Your Ref: OWQC18514
Our Ref: EP/62/18/HH
Please ask for:
Mr Z Denton

31st May 2018

First floor extensions, 3 No. julliette balconies to rear elevation & roof alterations.
3 Michel Grove East Preston

18 / 4513 / 7

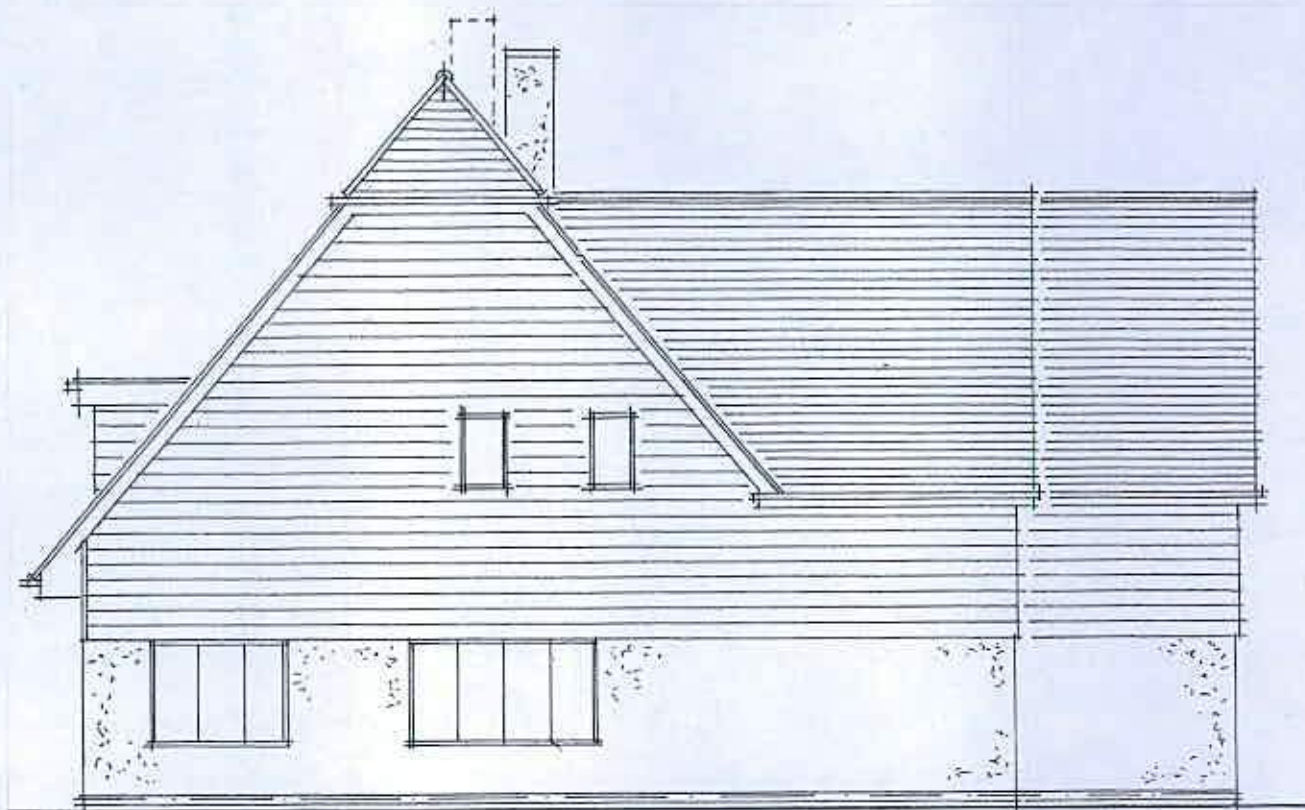
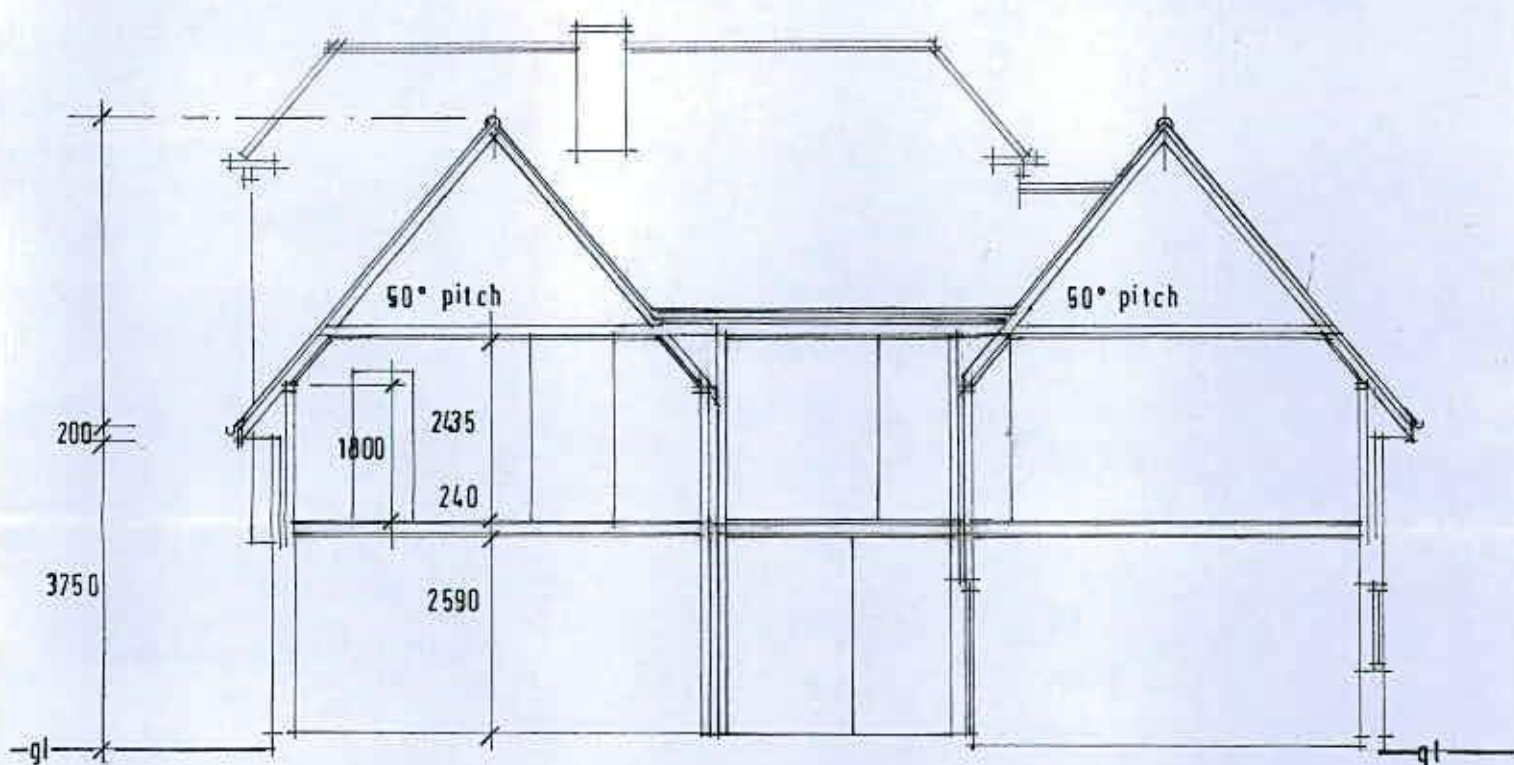
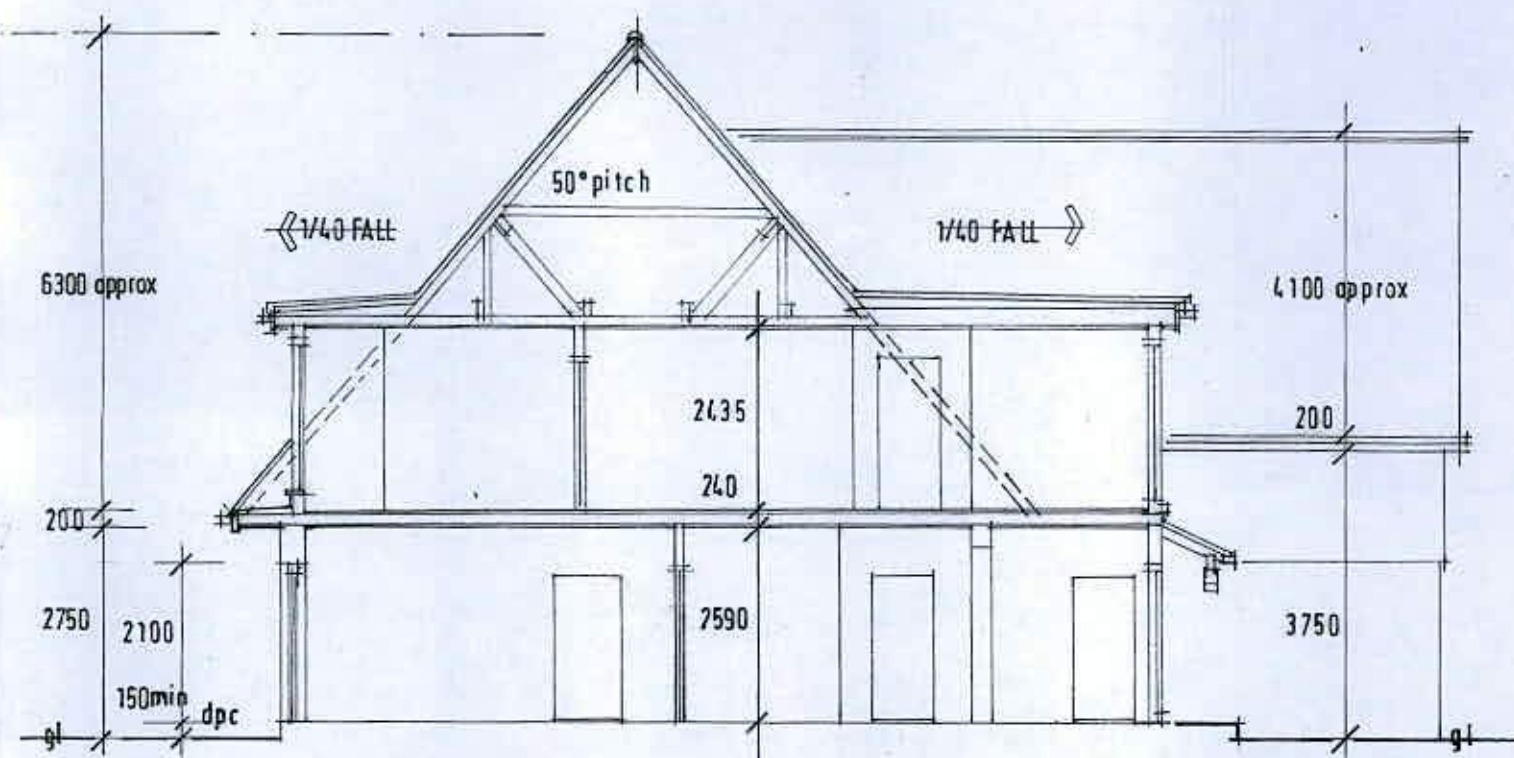
The committee agreed to object to this proposal as it is contrary to section 4.12 of Policy 1 of the made East Preston Neighbourhood Plan which states, The materials used in new or altered buildings should harmonise in both colour and texture with the materials used in adjoining buildings.

The committee is concerned the finishes will be out-of-keeping with neighbouring properties and will result in a very stark, monochrome building not in harmony with nearby buildings. The smooth grey roof tiles will also be unlike any roofing material in the immediate neighbourhood. Cedral planking of any colour is not a vernacular style in East Preston and silver grey will again feel very monochrome.
